<input type="checkbox"/> Sidewalk Waiver (Form V2)		
<b>SITE PLANS</b>		<input type="checkbox"/> Waiver to IDO (Form V2)	<b>APPEAL</b>
<input checked="" type="checkbox"/> DRB Site Plan (Form P2)	<input type="checkbox"/> Waiver to DPM (Form V2)	<input type="checkbox"/> Decision of DRB (Form A)	
<b>BRIEF DESCRIPTION OF REQUEST</b>			
Apartment complex development

**RE: Sonata Unit 4 Trails Apartments  
Tracts 1, 2, and 3, The Trails Unit 4  
Second DRB Submittal**

RESPEC, agent for Sonata Trails, LLC, owner of the above referenced property, is requesting approval from the Development Review Board (DRB) on this Site Development Plan submitted for your consideration. This is the second submittal to the DRB for this project. The first hearing was held on June 3, 2020. Below is a response to comments received at the first DRB meeting.

PROJECT NAME:  
**SONATA TRAILS UNIT 4 APARTMENTS**

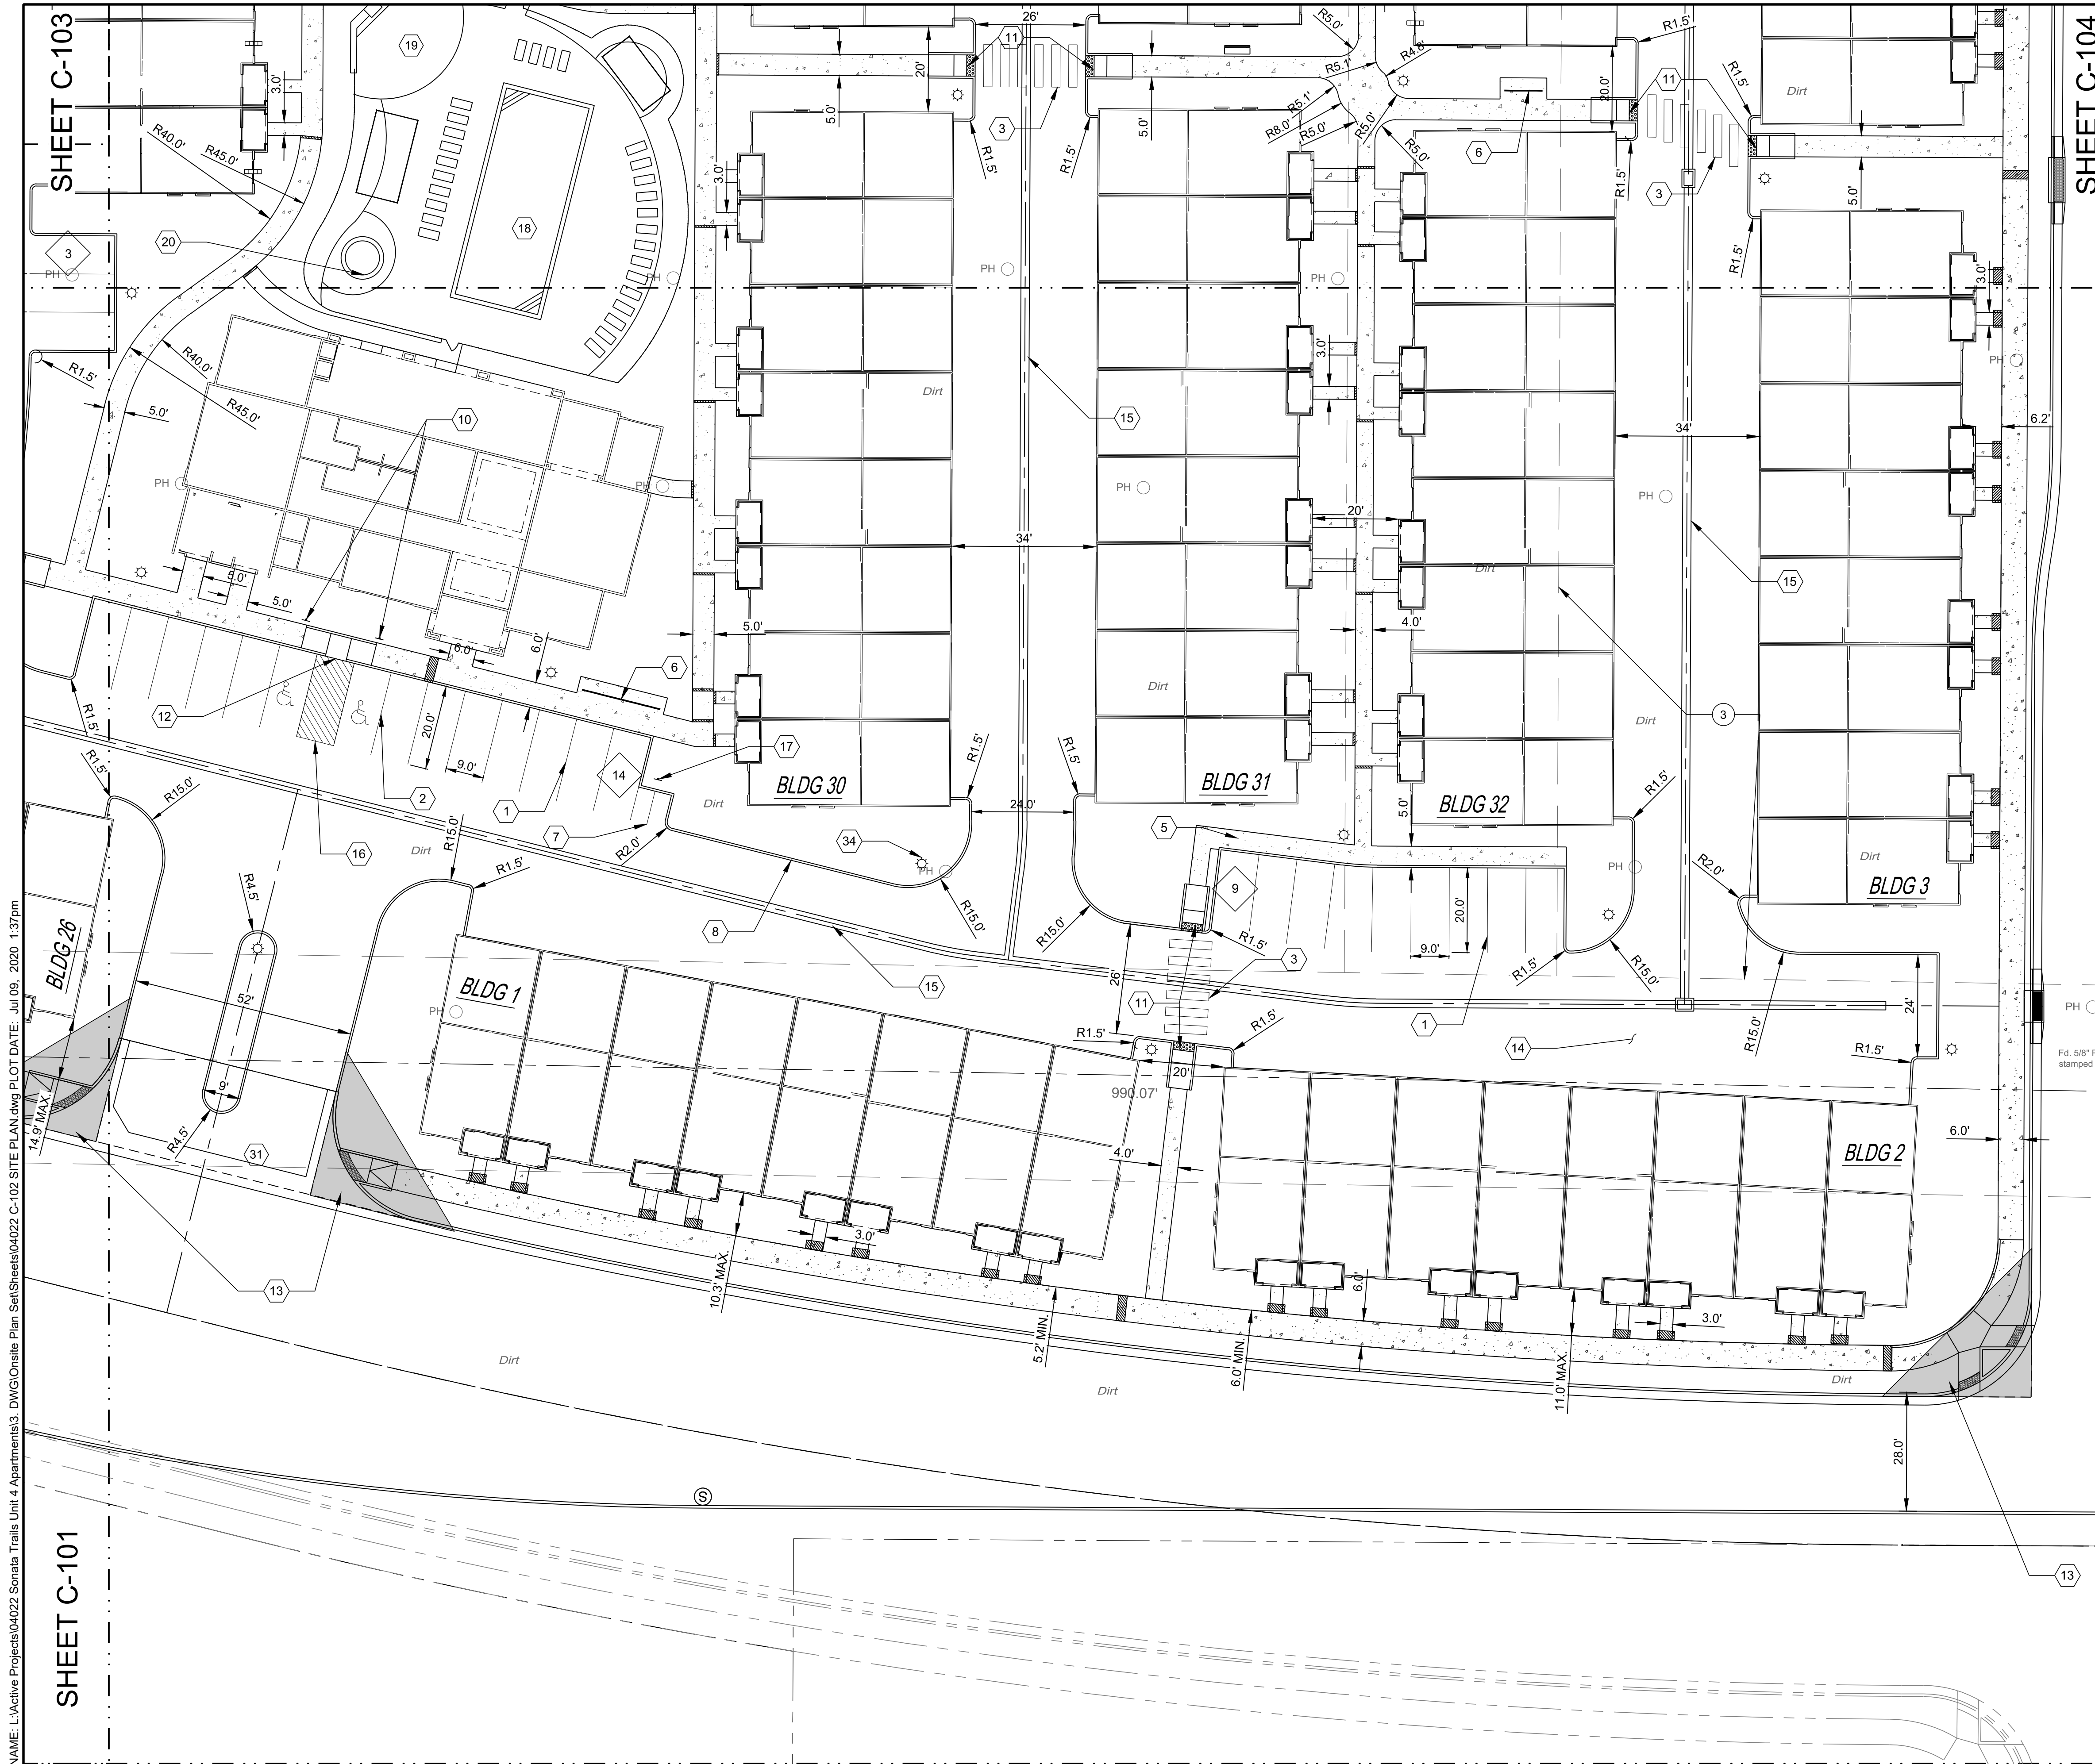
3. On the site plan, label roadway widths for surrounding streets that correspond with the roadway cross-sections and infrastructure list.  
/ Roadway width labels have been provided for adjacent streets. See revised site plan.

6. Add keyed notes for all ADA ramps on the site plan.  
/ Keyed notes 11 & 12 callout ADA ramps. The ADA ramp symbols have been added to the legend. See revised site plan.

9. Label all on-site walkway widths, and add a keyed note for crosswalks on the site plan.  
/ All on-site walkway widths have been labeled. A keyed note for crosswalks has been provided and a symbol has been provided in the legend. See revised site plan.

- The Code Enforcement signature line is missing from the Site Plan on Sheet C-100.  
/ Code Enforcement signature line has been added. See revised site plan.
- The Color, Reflectivity, and Roof-Mounted Equipment requirements for the Northwest Mesa Escarpment – VPO-2 must be met as listed below:

- The Site Plan mentions the proposed development as multi-family dwellings, but the design of the proposed dwellings seem to be townhomes. Please clarify this on the Site Plan.

- There appear to be pedestrian connections to sidewalks along the street frontages of Chatsworth Avenue and Treeline Avenue, but it's not clear on the Site Plan if there would be sidewalks along those frontages.

- Staff requests that benches be placed in the open space areas on the site outside of the central recreational area.
- / Benches were provided in the western open space area. Additional benches have been added throughout the site outside of the central recreational area. See revised site plan.

- / Four 1-bedroom units have been added to the second floor of the clubhouse building. We believe this meets the definition of a multi-family development rather than townhomes. See revised site plan.

- / Sidewalks and trails along property frontages will be built with this project. A hatch for off-site walkways has been added for clarity.
- Frontier Elm trees depicted on the Landscape Plan are not on the City of Albuquerque's Tree List.
